Belsay Awakes Play Layout  
- Annotated Changes

BY  
WH/TH

The wild man and wild woman lookout

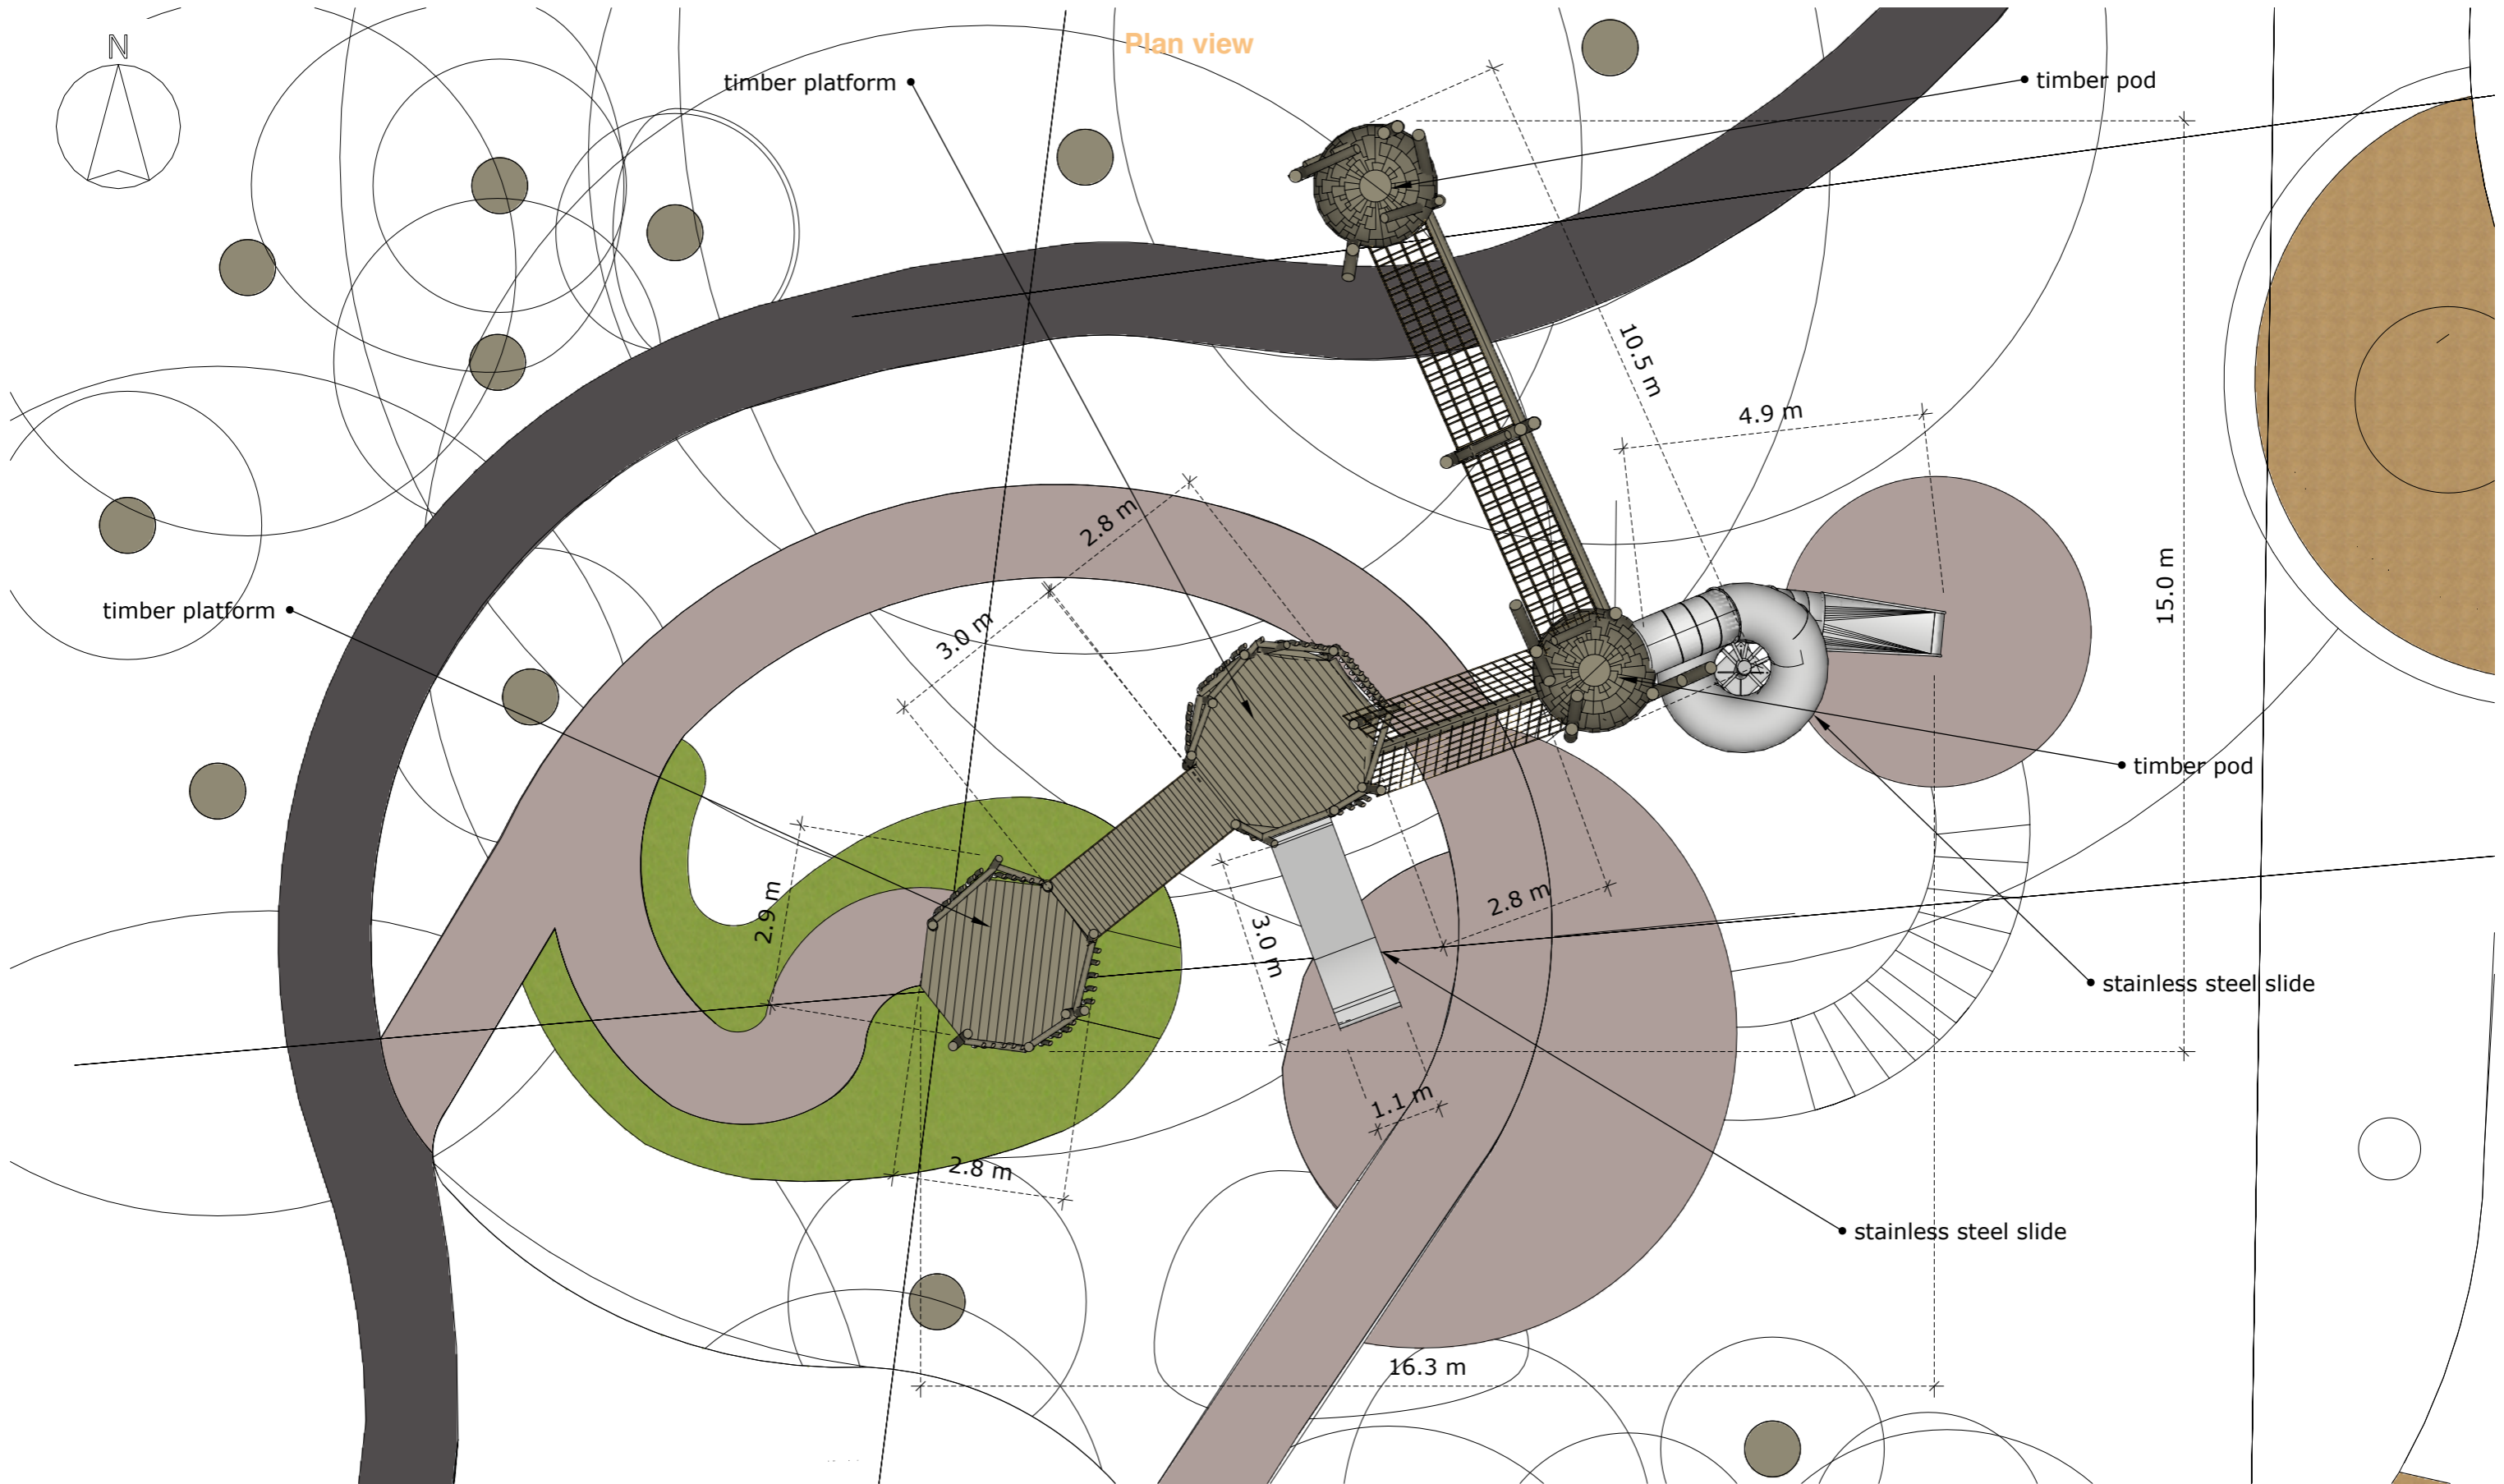
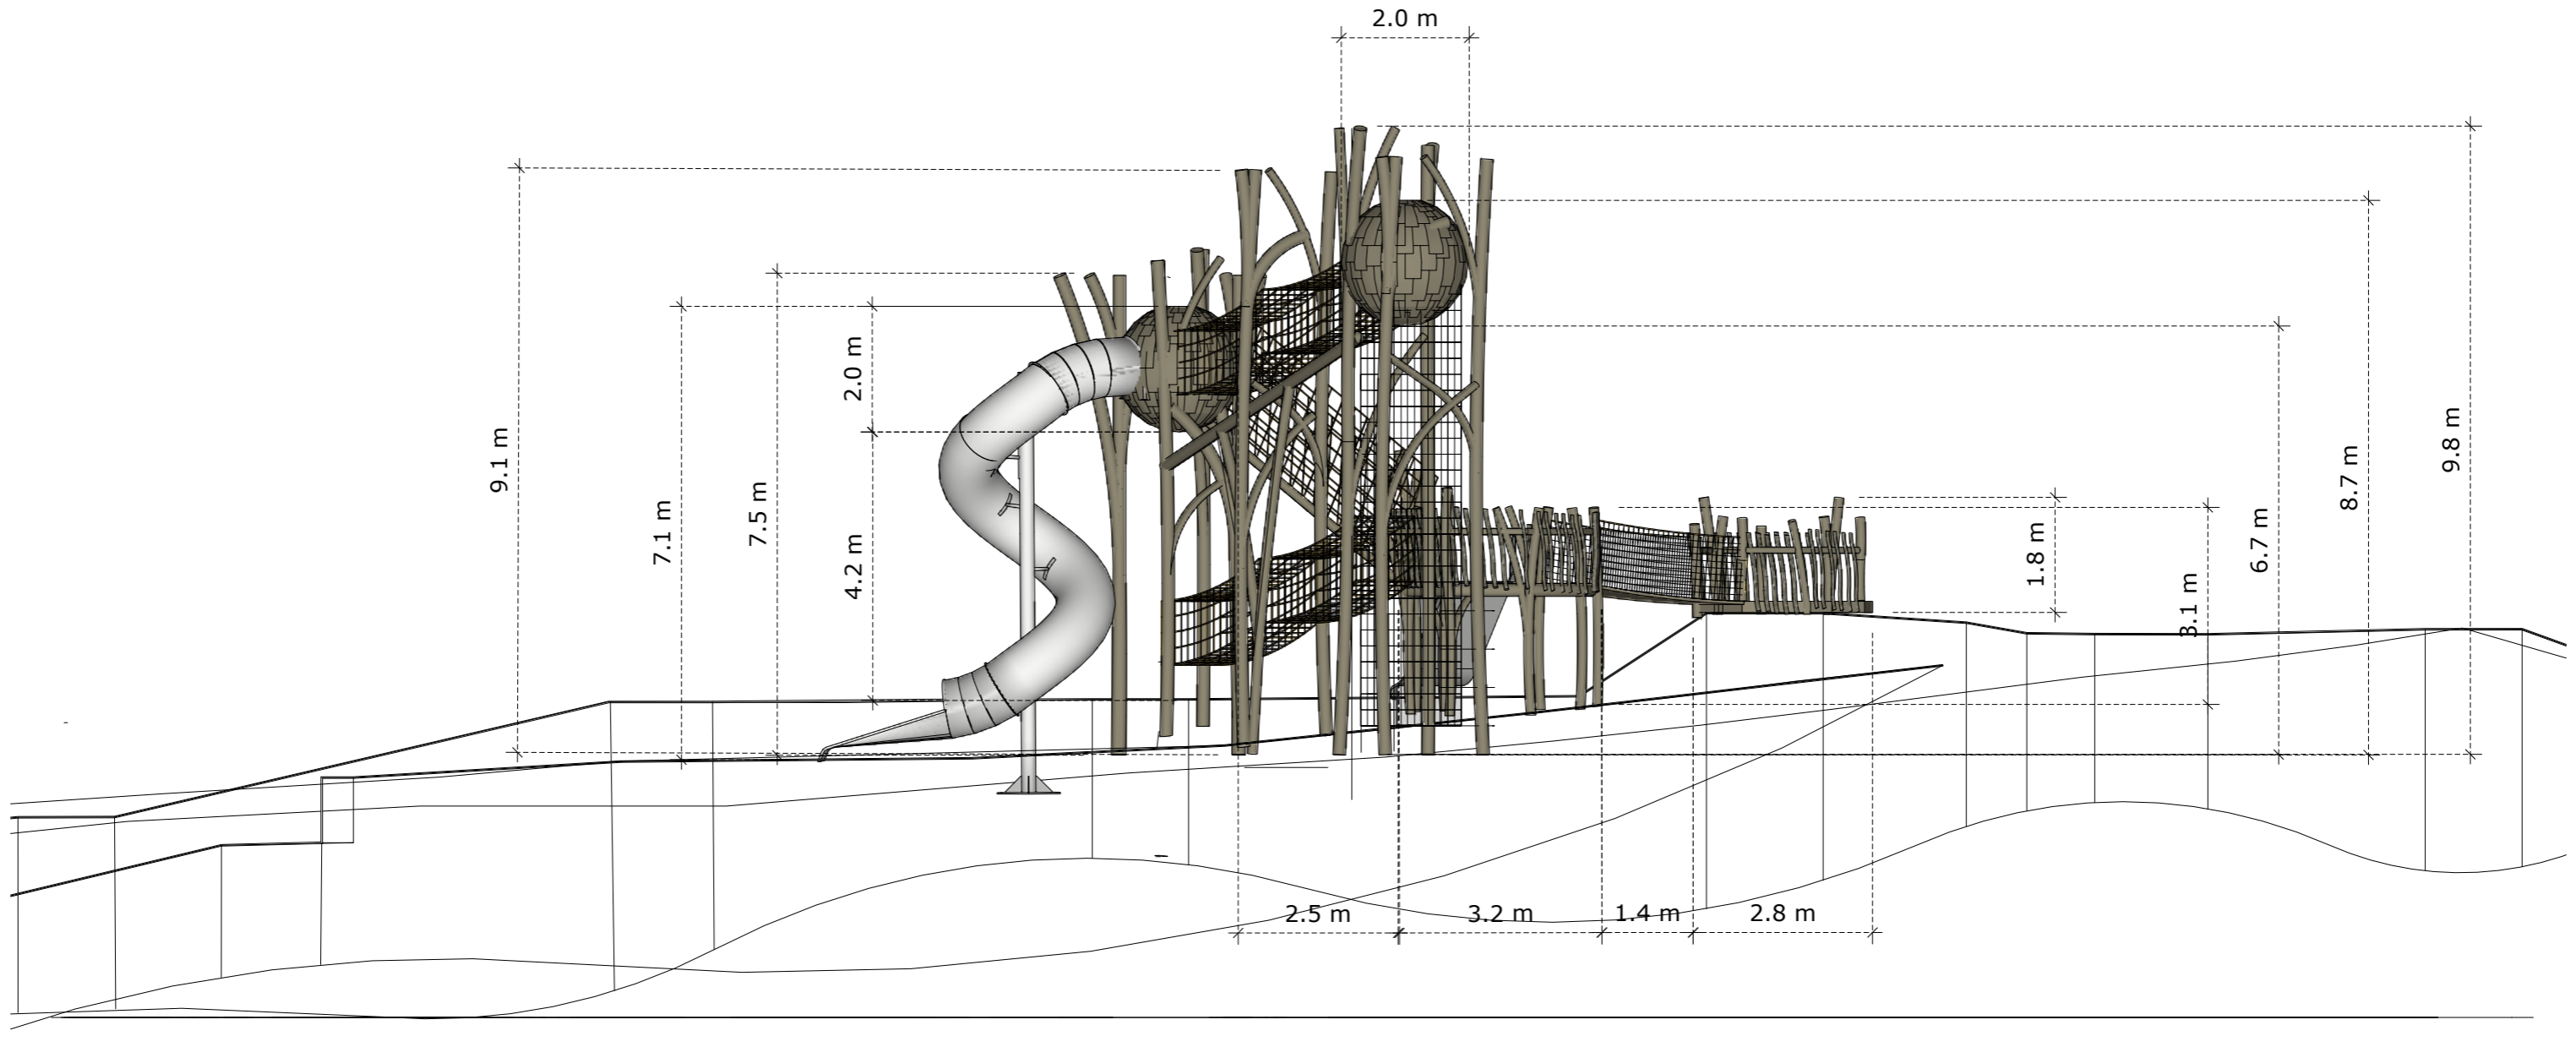
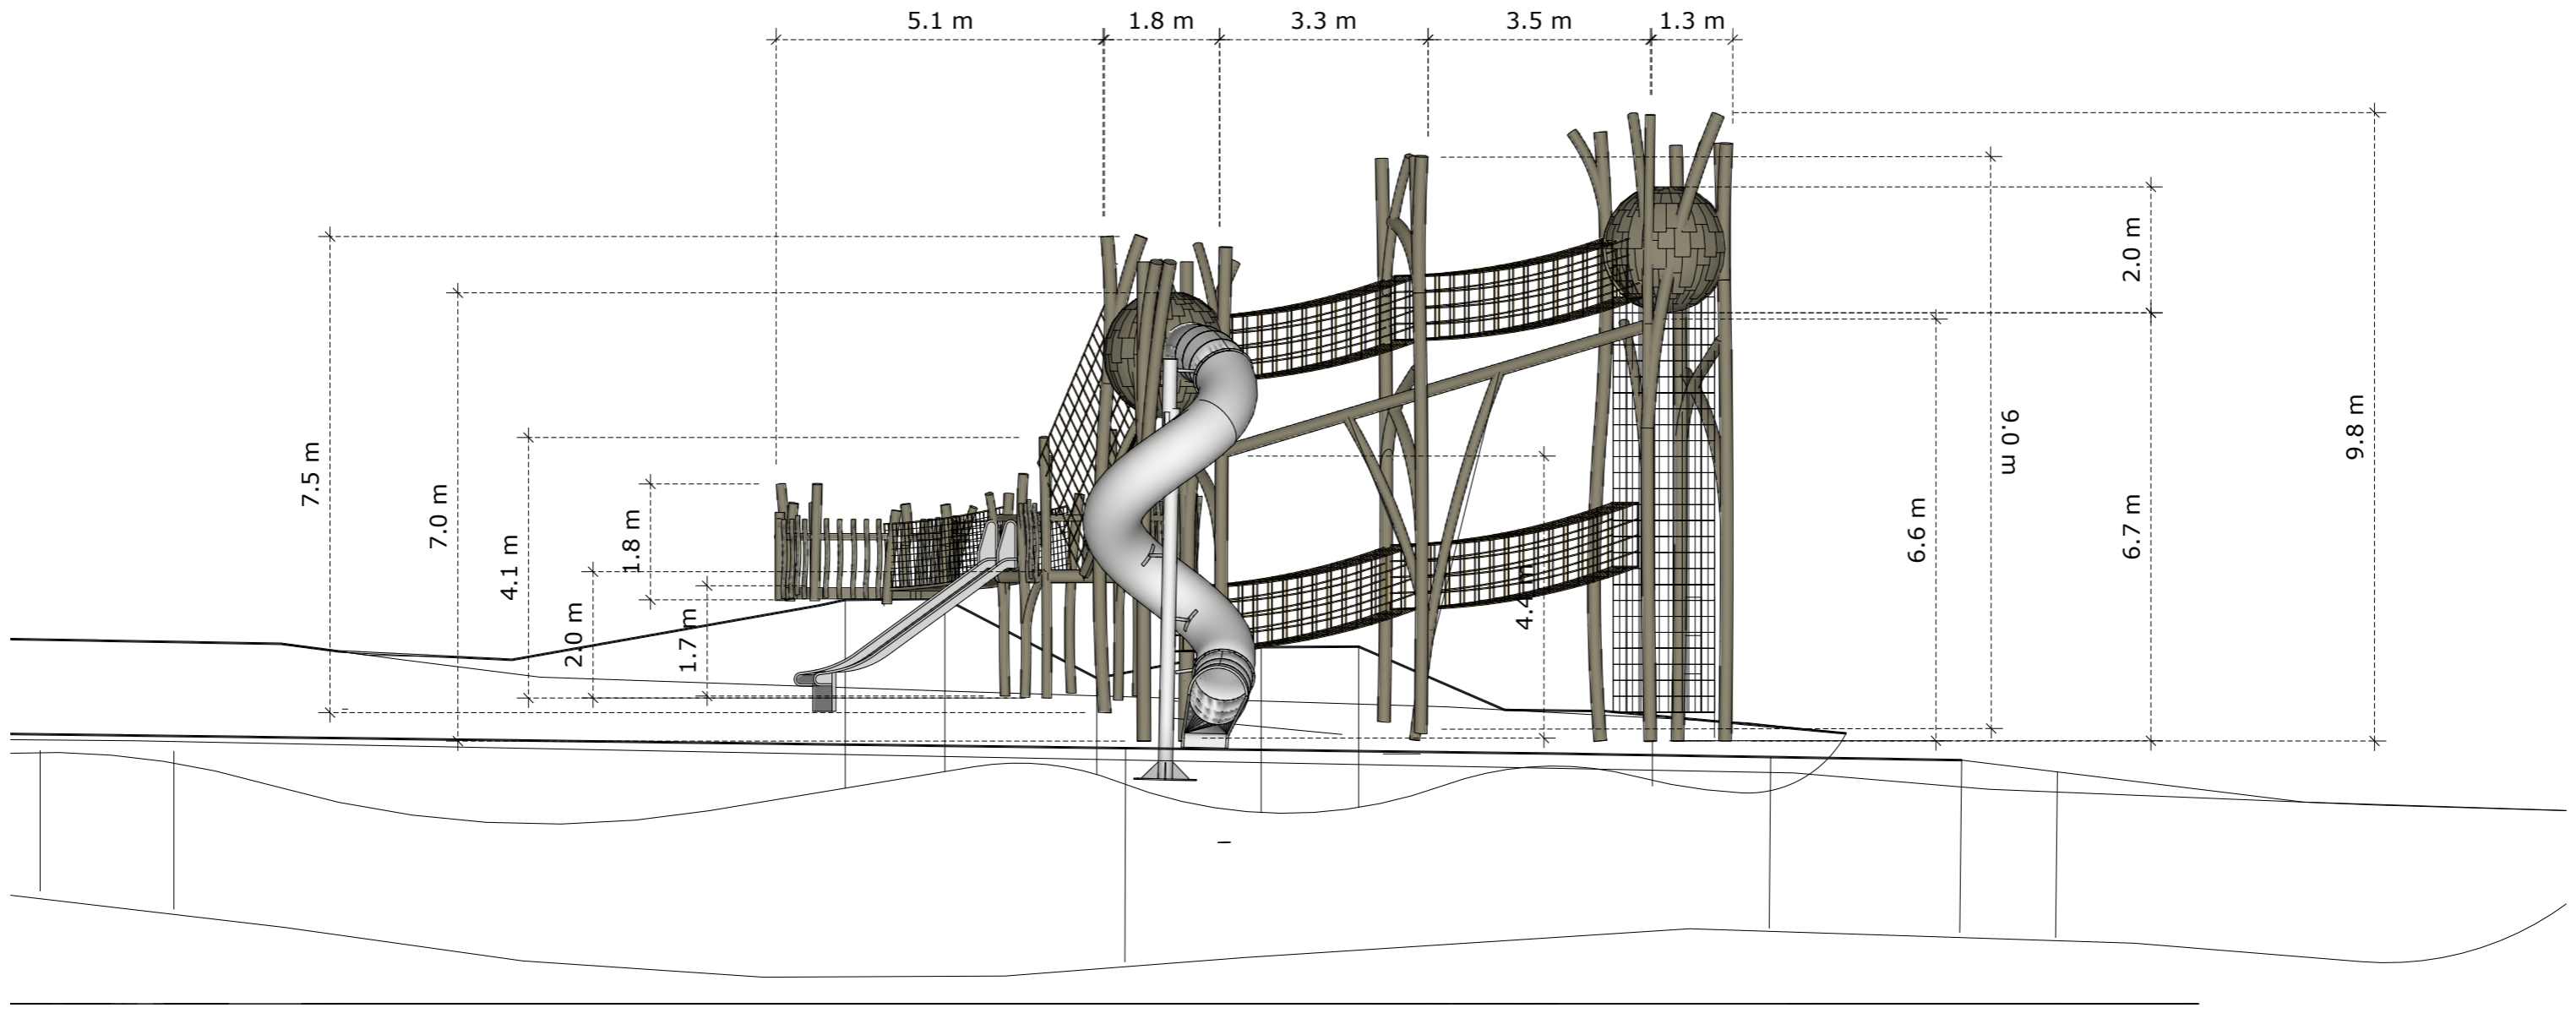
Slight changes in geometry in response to structural engineer's feedback and to further topographic information from Southern Green. Addition of vertical and horizontal climbing nets. Slide partially timber clad.
